TECHNICAL MEMO

Our Ref: 4937_002M_1-0_CW

Date: 3 November 2020

**SUBJECT: STANFORD HOUSE, 9 NESTLES AVENUE, HAYES
51175/APP/2020/2543
AUGUST 2020 NOISE AND VIBRATION ASSESSMENT REVIEW**

North Elevation

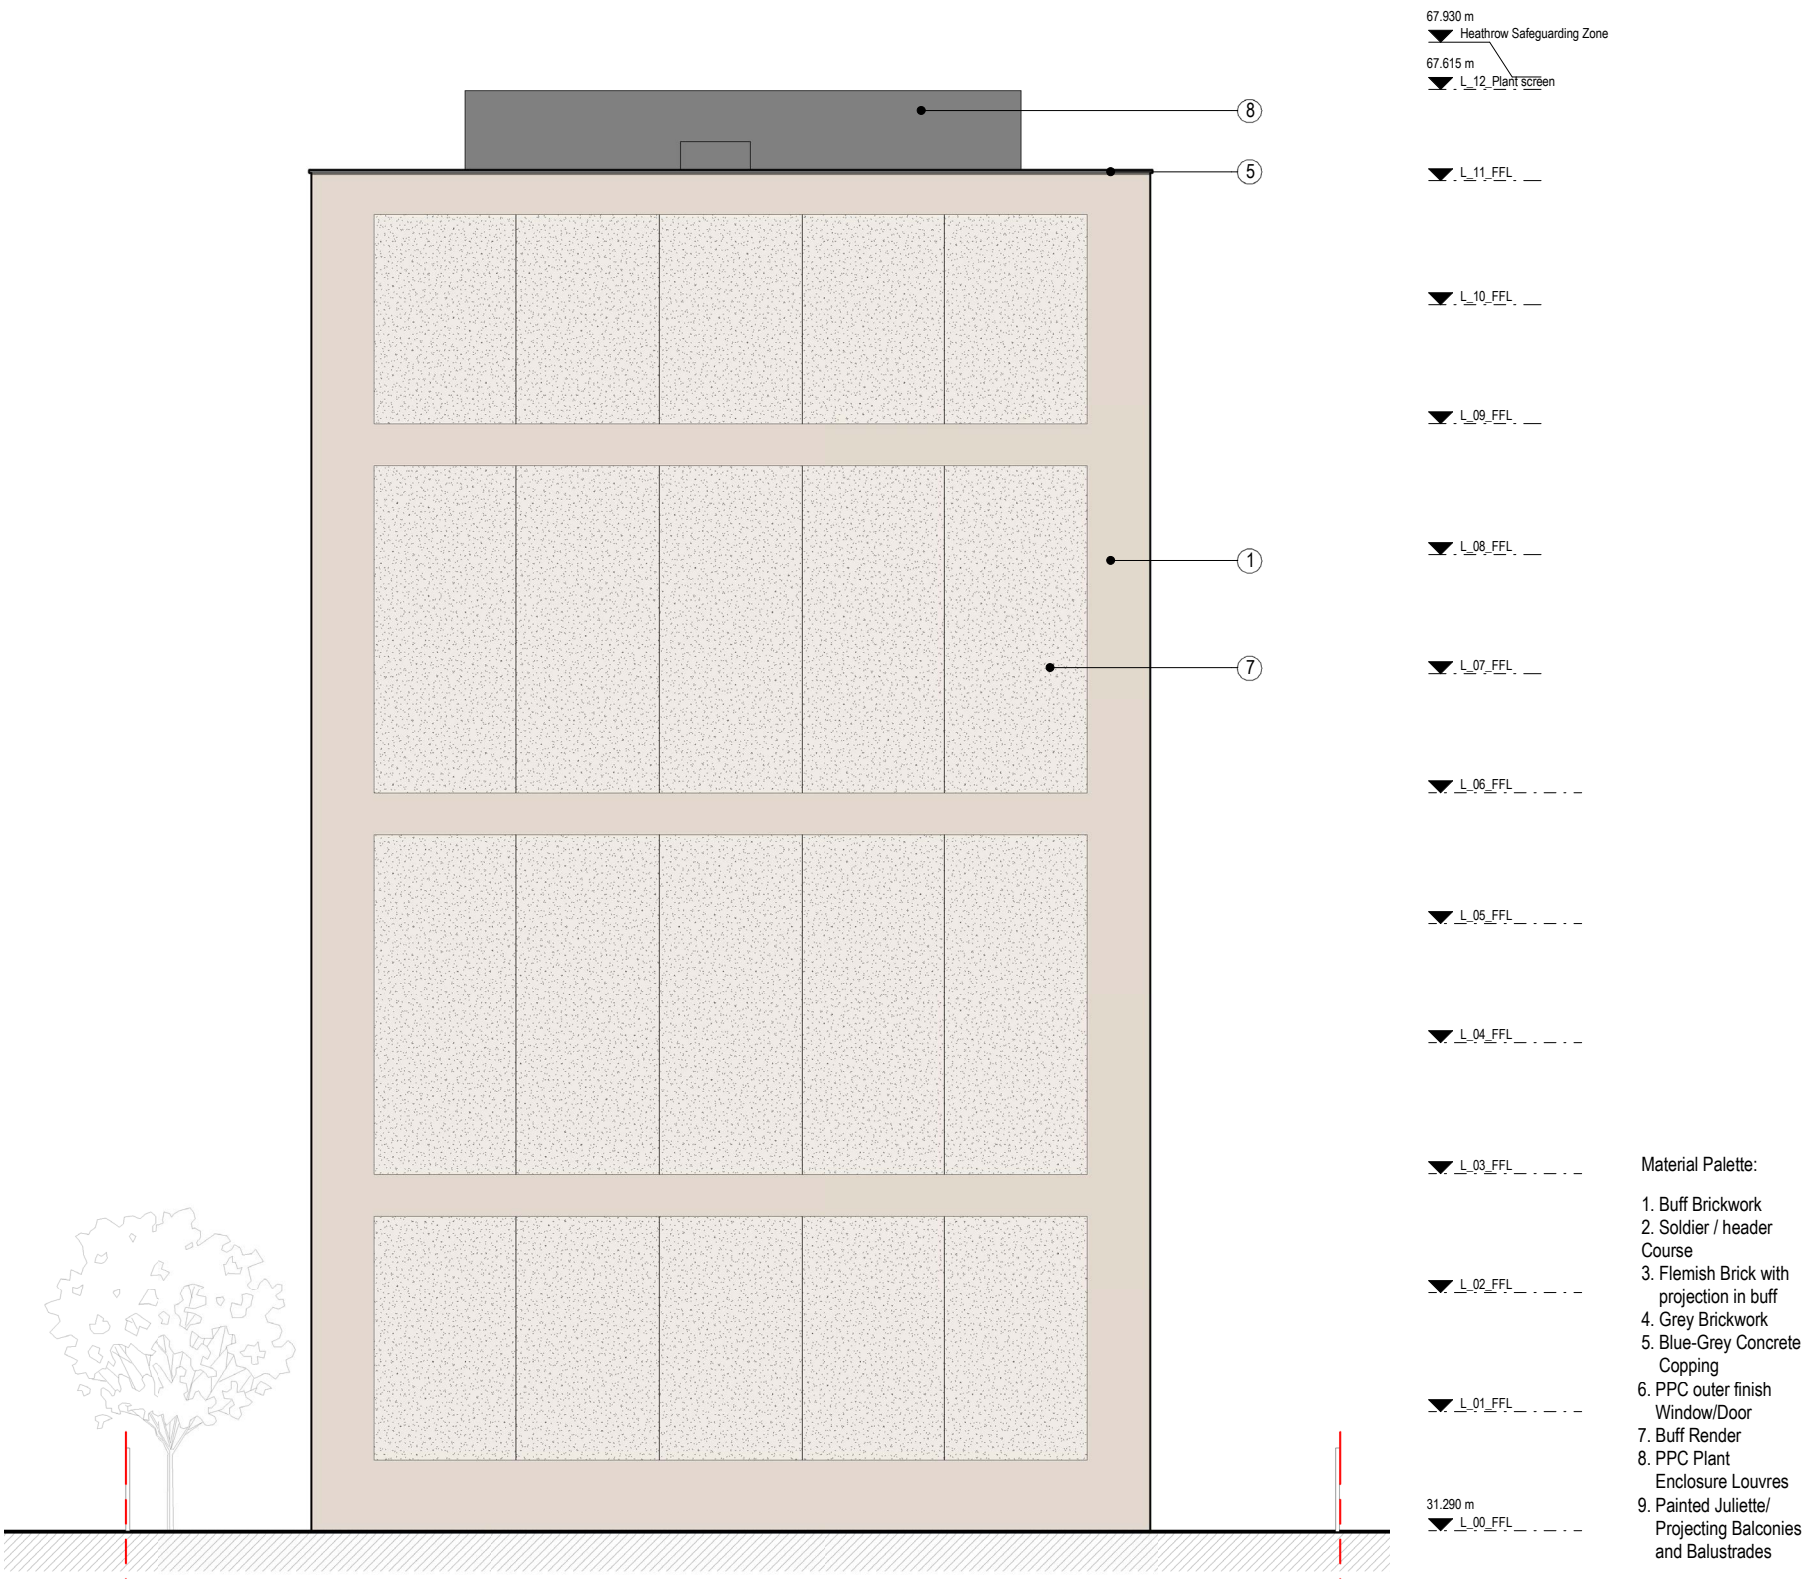
In the event, a number of measures are listed as part of the design. These include the northern elevation being a blank façade (but which is perhaps more about enabling adjoining development than providing acoustic screening), the use of MVHR units (as a result of the SAP calculations), the use of solid balustrades to balconies on the western elevation and acoustically absorptive soffits to minimise potential noise reflections from the underside of projecting balconies. The proposed block is also set further back from 7 Nestles Avenue than the previous scheme design, and with standard thermal double-glazing being more than sufficient acoustically.
